Jeanie Bourke - Re: 83 Quebec St. - SF calcs

From: Jeanie Bourke
To: George Froehlich; Phil Kaplan
Date: 4/21/2015 1:58 PM
Subject: Re: 83 Quebec St. - SF calcs
CC: Jonathan Culley; Richard Lo; Tammy Munson

Thank you for sending this information and meeting last week. Further staff discussion and technical assistance from ICC has lead to the following decision for the type of sprinkler system at 71 Quebec St., Fast Track BP#2015-02350.

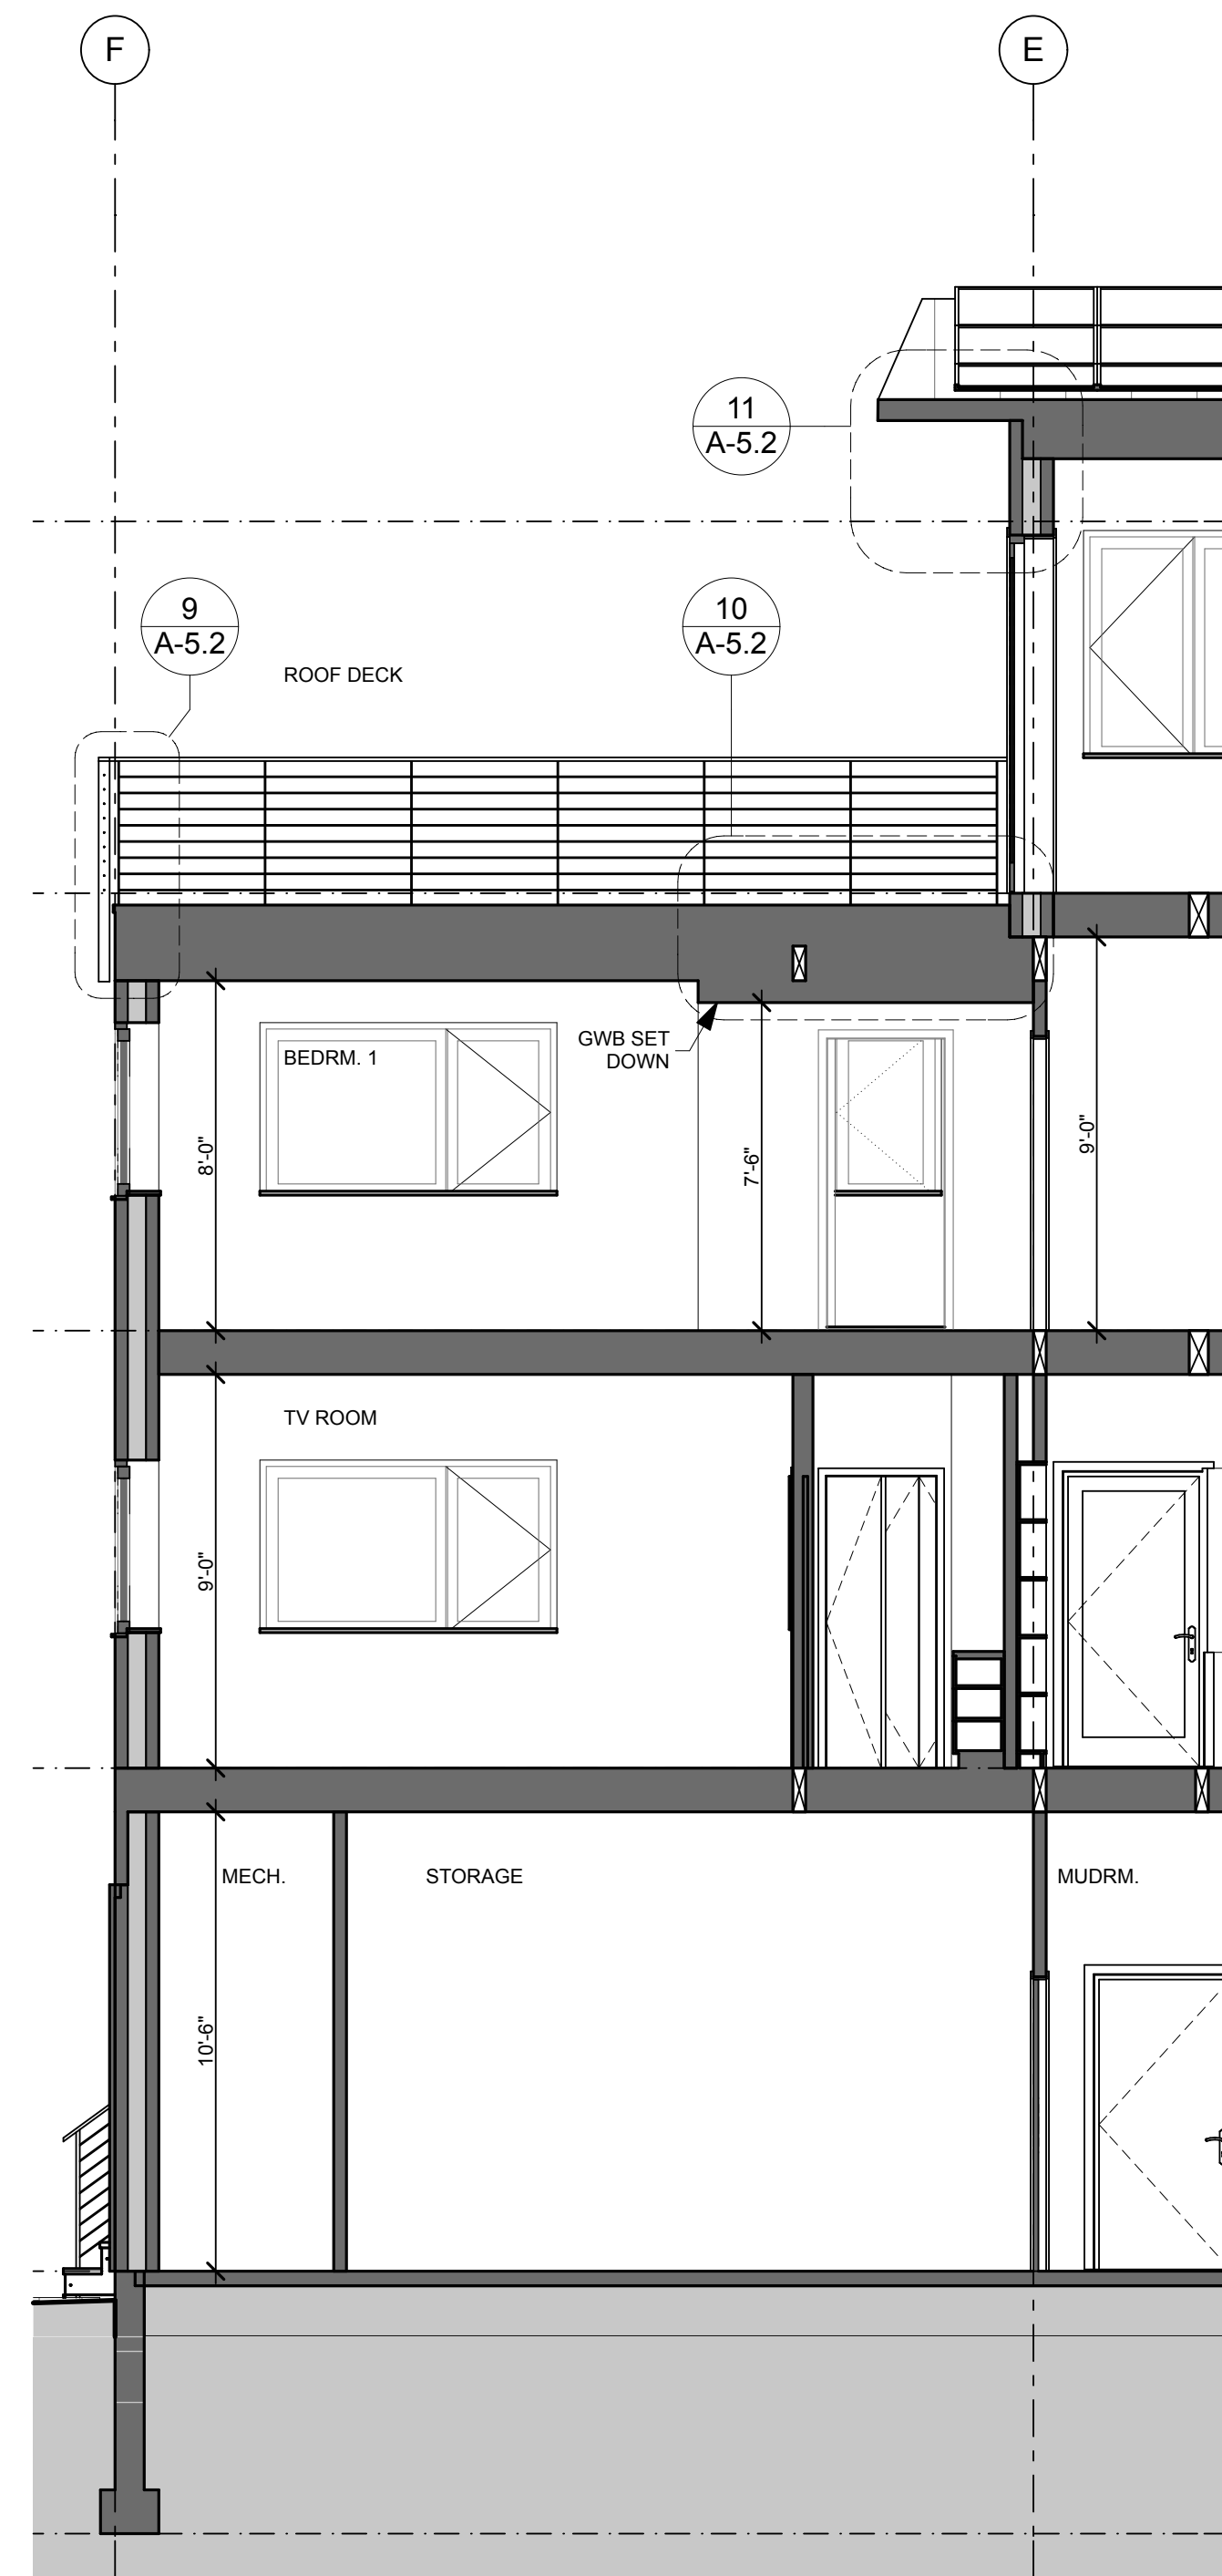
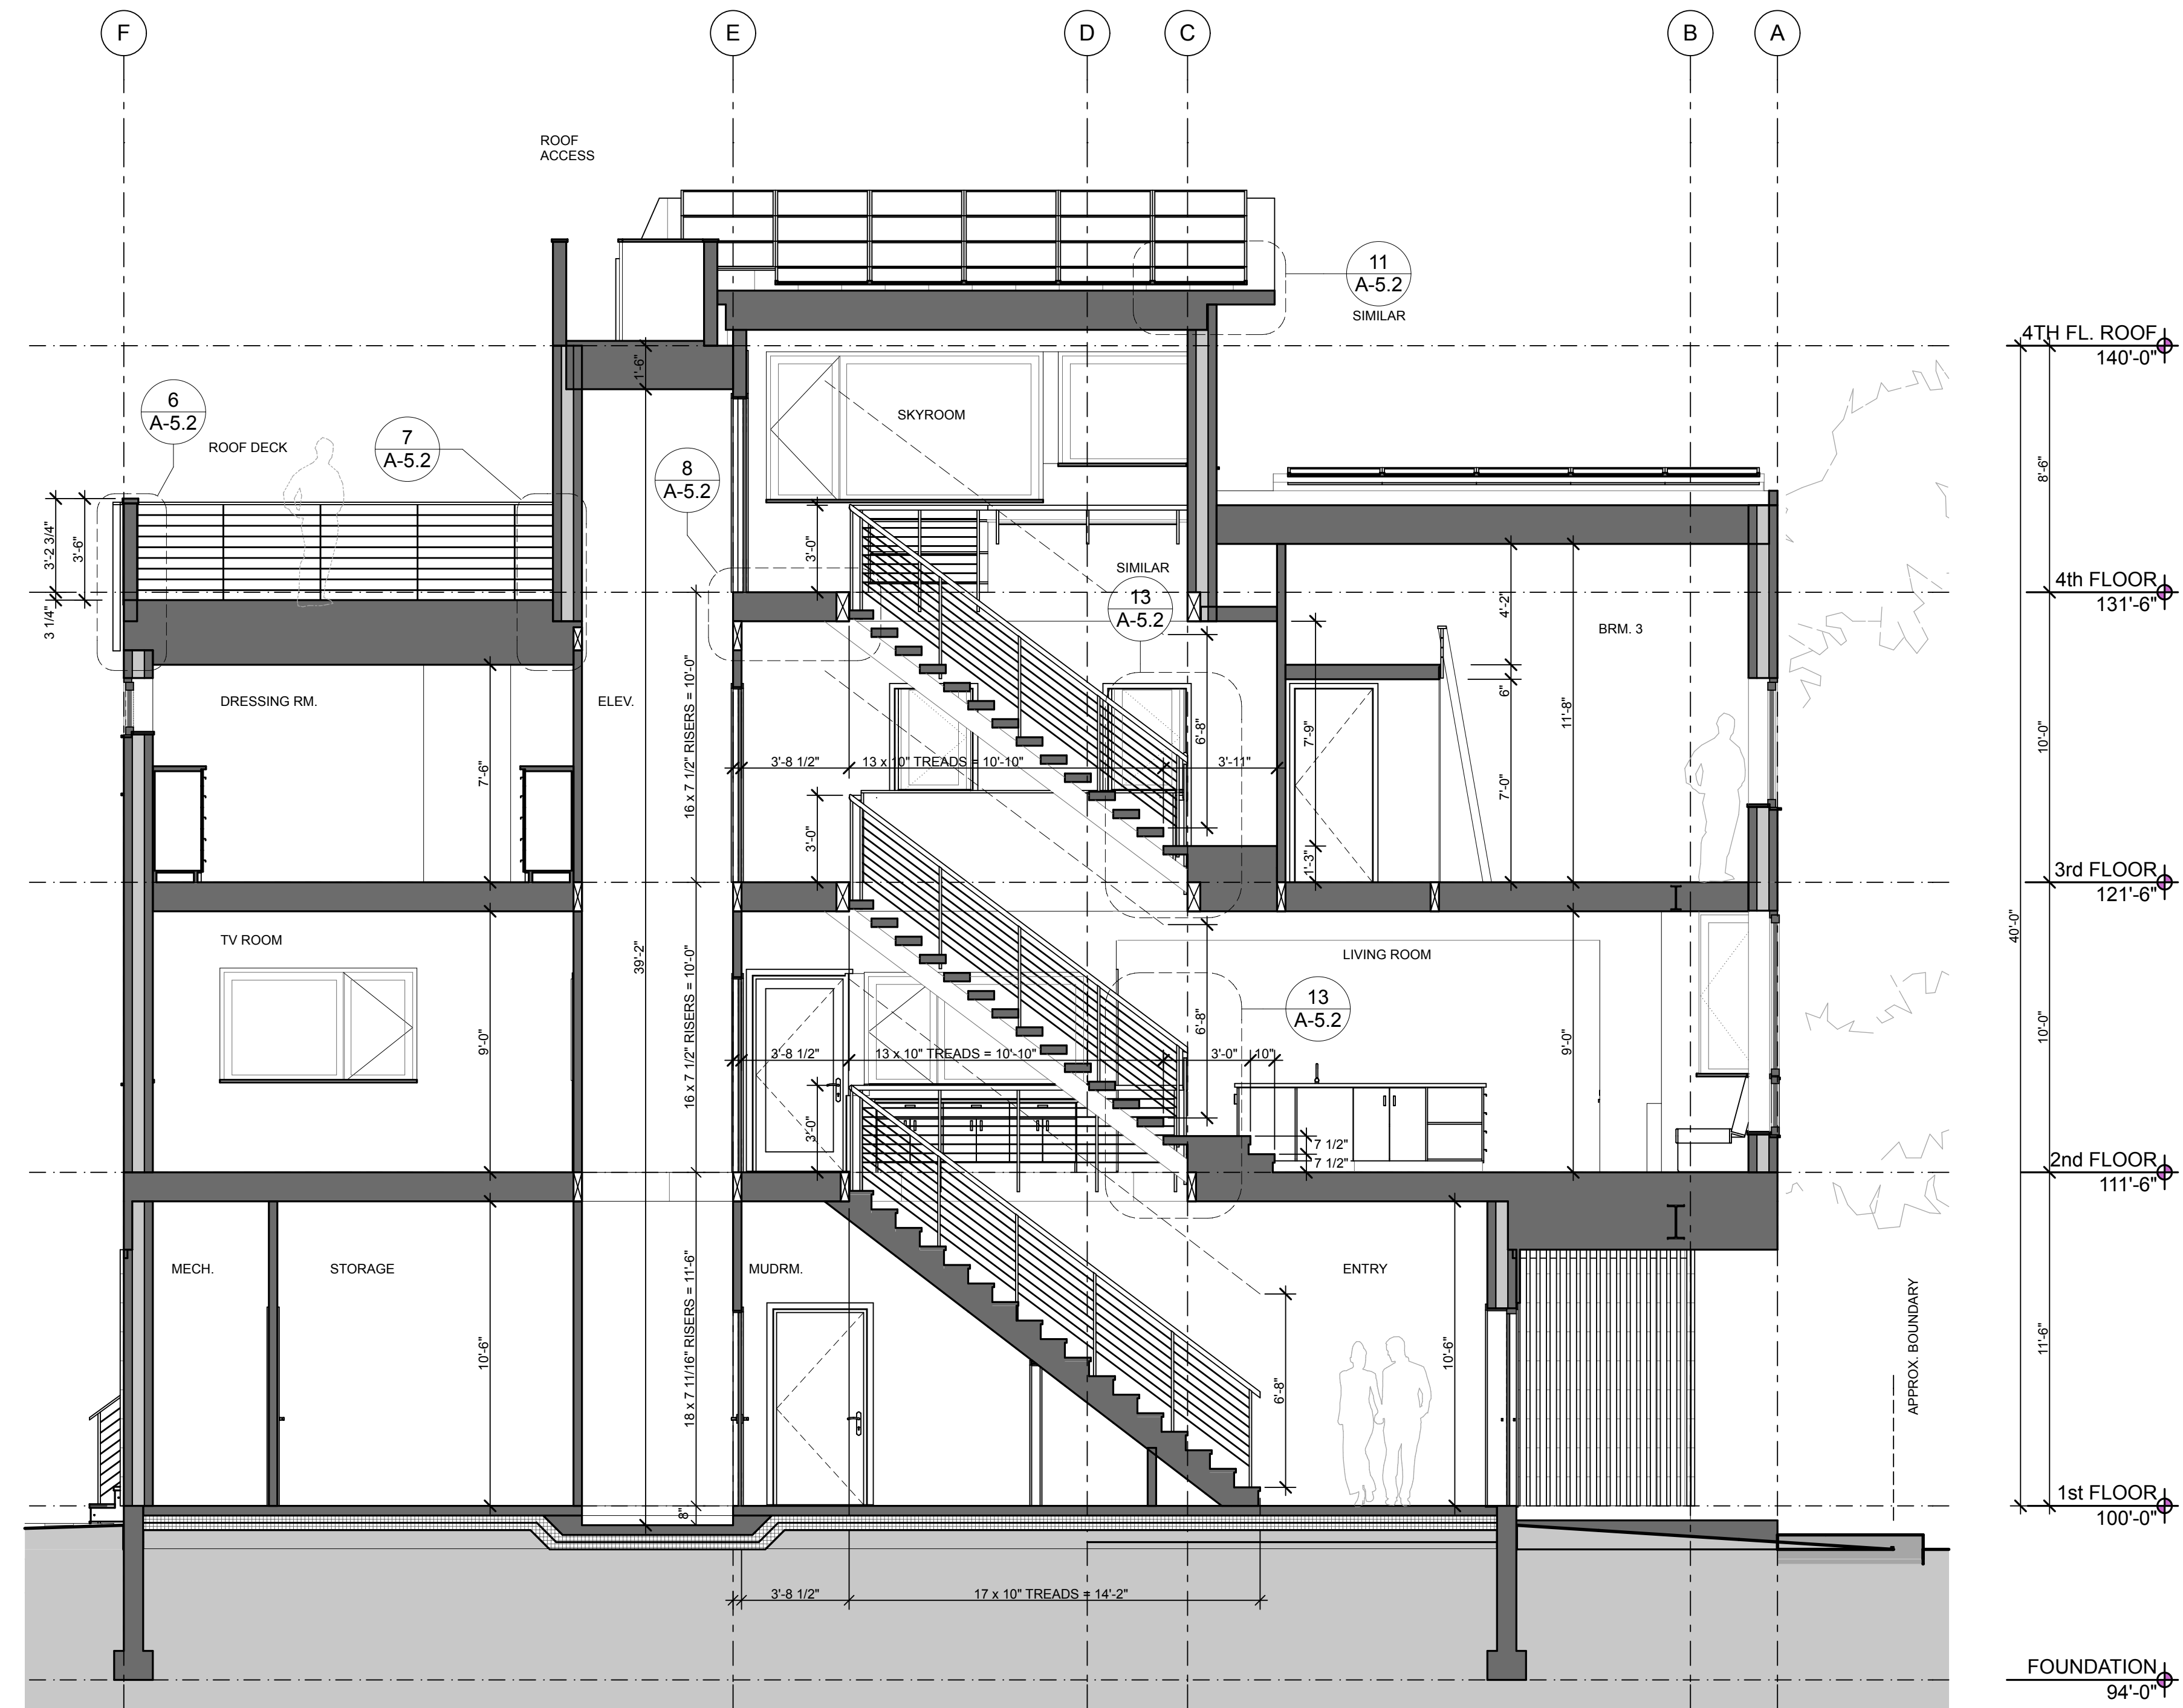
The City's position on this project is that this structure is to be reviewed under the IBC, first, due to the number of stories and second, the height. By building code definition, this is a 4 story building, and therefore it does not fall under the scope of work for the IRC, One and Two Family code.

Per IBC Table 503, Allowable Building Heights and Areas, type 5B construction for group R-3 allows 3 stories and 40'. IBC Sec. 504.2, Automatic Sprinkler System Increase, the installation of an NFPA 13R system allows an increase of 1 story and 20' of height. This system is required to be installed for this building as the evidence is clear that it is 4 stories above grade plane and 45' in height.

Please provide a revised plan sheet, BMS-A0-Cover-20141006-Permit with revisions to reflect the changes per the applicable building code provisions.
